From: Simon Davis
Sent: 09 November 2021 17:39
To: Nicola Spencer; Hannah Riddle
Subject: SUB PLAN REQUEST - BN/134/21/DOC
Attachments: 18158 Addendum Letter Report Rev2_ISSUE.pdf; 108.5009.505.E.pdf; 108.5009.503.G.pdf; 108.5009.502.F.pdf; 108.5009.504.F.pdf; 108.5009.501.D.pdf; 108.5009.751.B.pdf; 108.5009.705.G.pdf; 108.5009.706.F.pdf; 108.5009.704.A.pdf; 108.5009.703.A.pdf; 108.5009.552.B.pdf; 108.5009.506.F.pdf; 108.5009 - PERMEABLE PAVING 1in100.pdf; Response to Drainage Comments.pdf; 108.5009.703.A.pdf

From: Grace Palmer [REDACTED]
Sent: 01 November 2021 16:35
To: Simon Davis <Simon.Davis@arun.gov.uk>
Subject: RE: Planning Consultation on: BN/134/21/DOC

The engineers have jumped on this round of comments and responded/updated drawings with the typos or missing information to hopefully finalise queries now. See response in blue below for ease and attached updated drawings.

PBA Drawing No.	Revision
108.5009.503	G

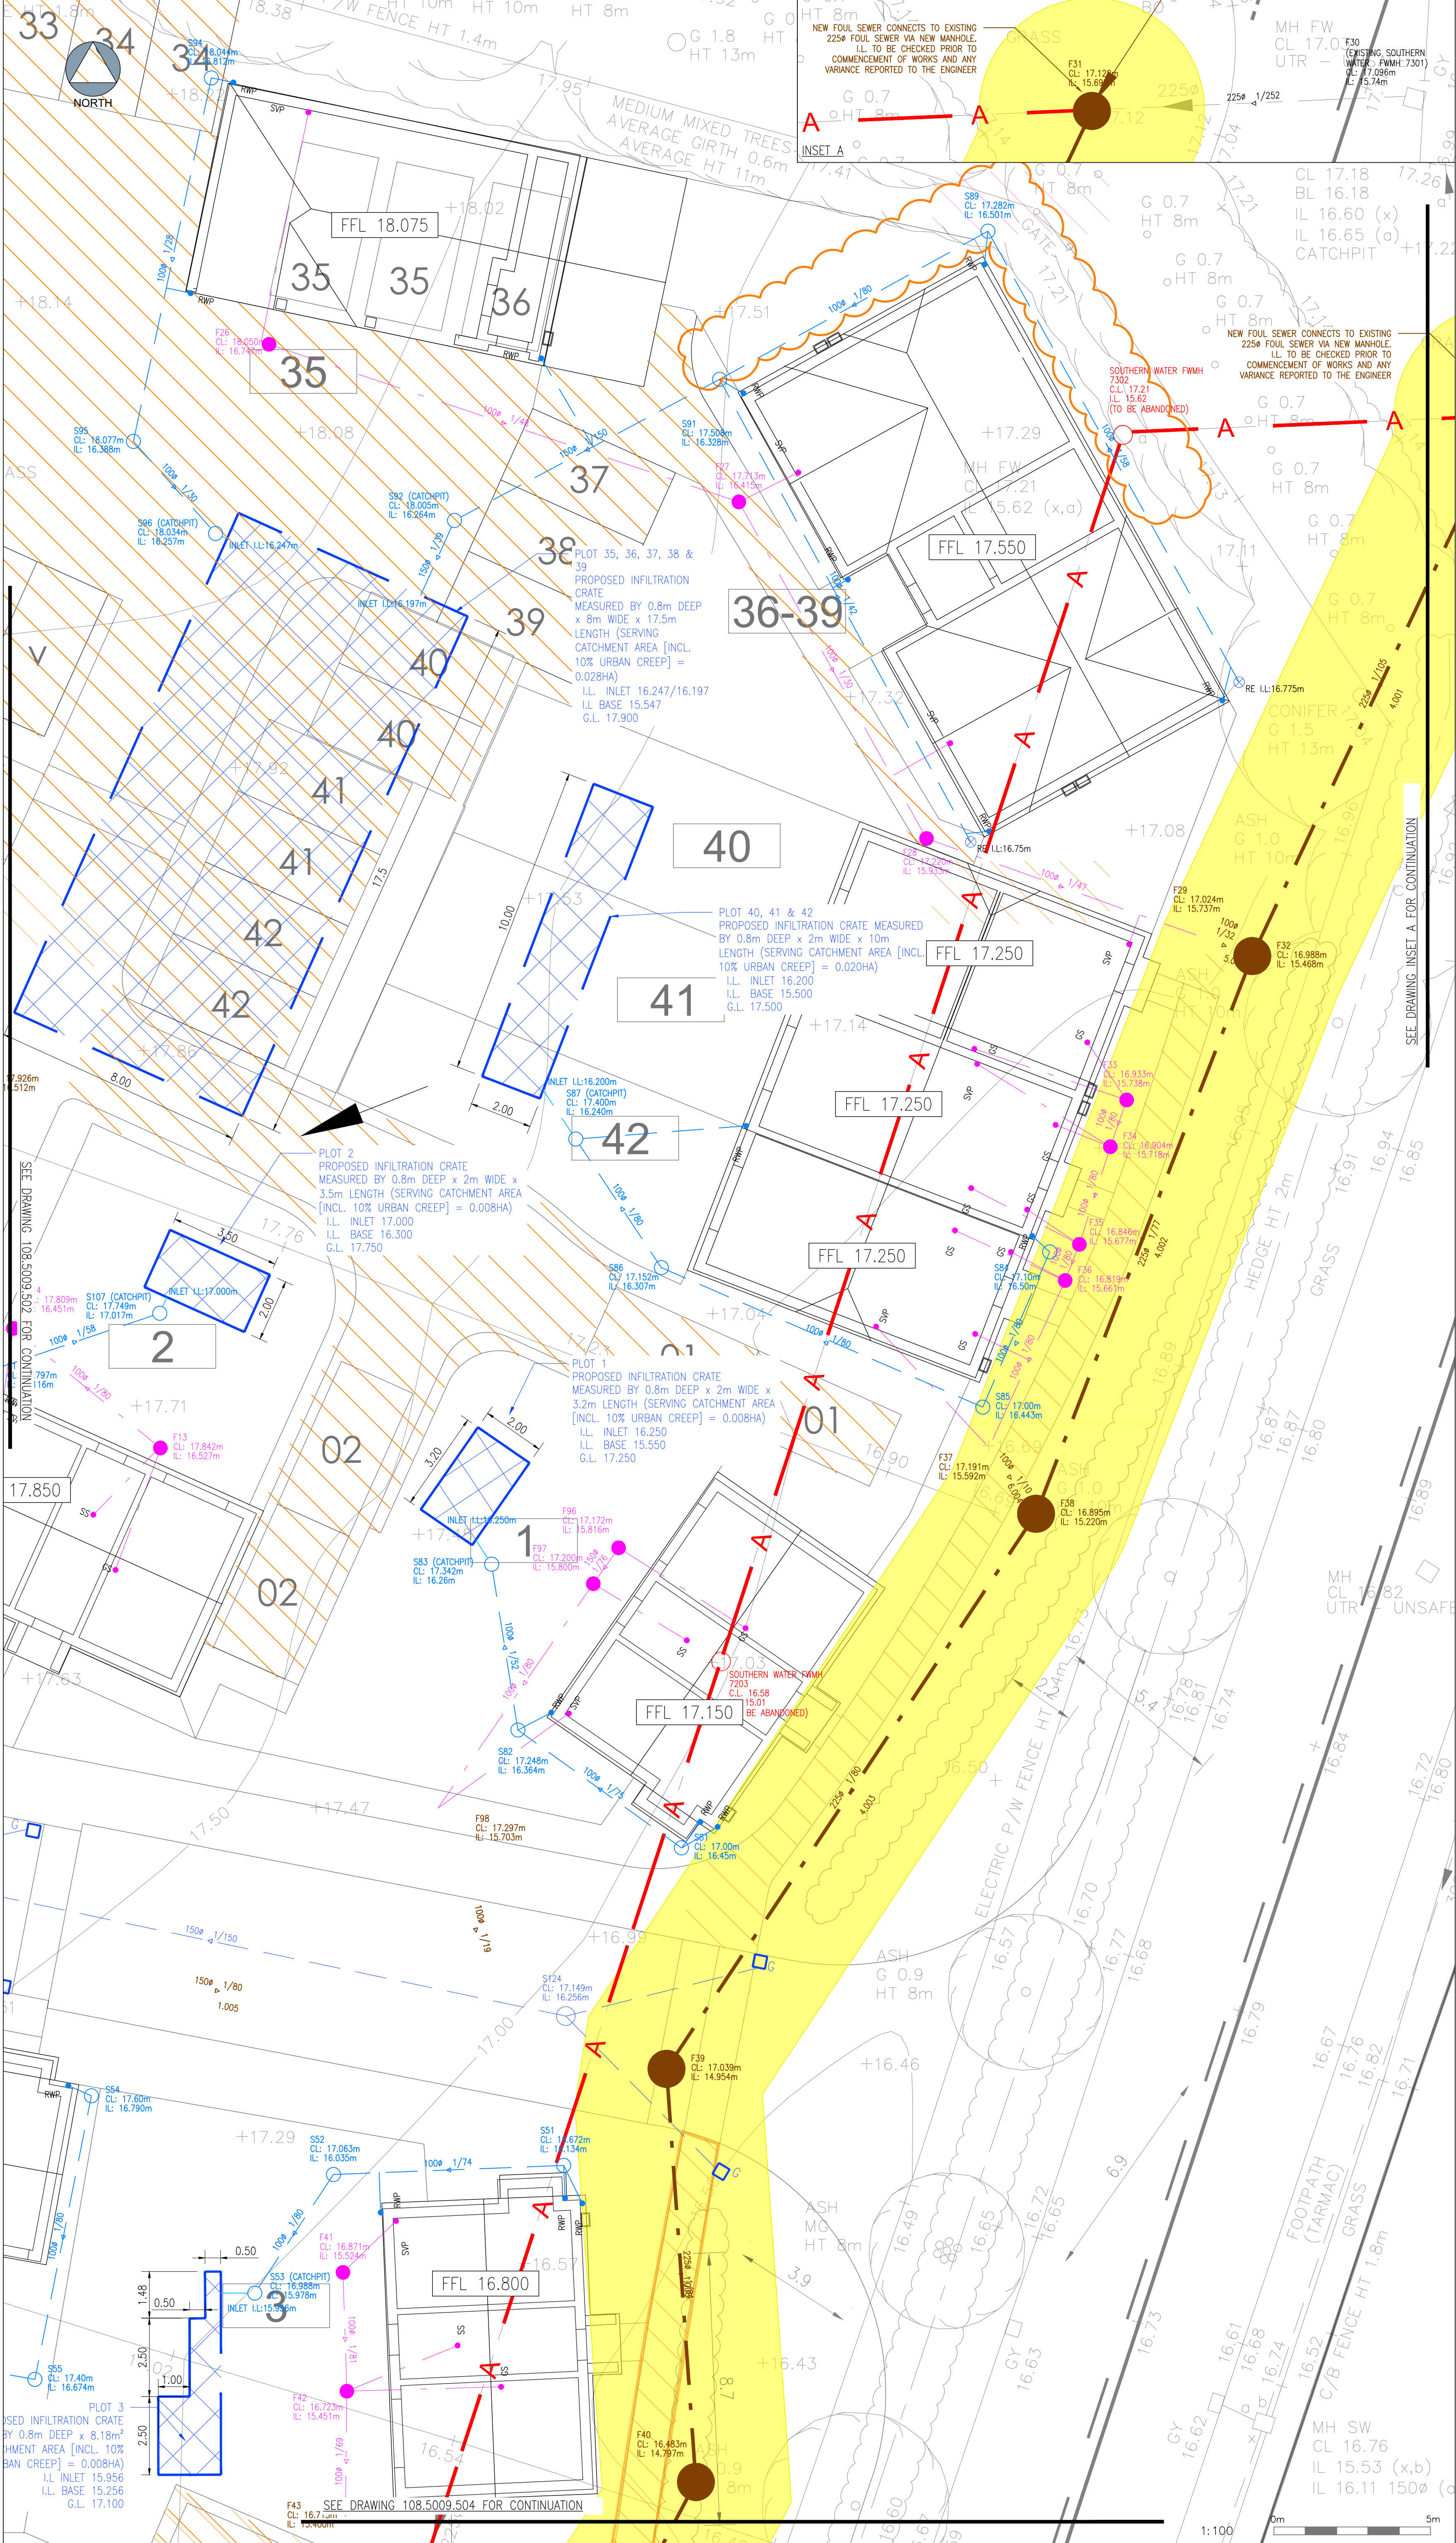
7. Capping layer below type 3 on the permeable paving must state “no fines”. Please also clearly label the base geotextile.

Permeable paving specification updated to state ‘no fines’ on capping layer – drawings 703, 704, 705, 706, 751, 552 and drawings 501-506 updated accordingly
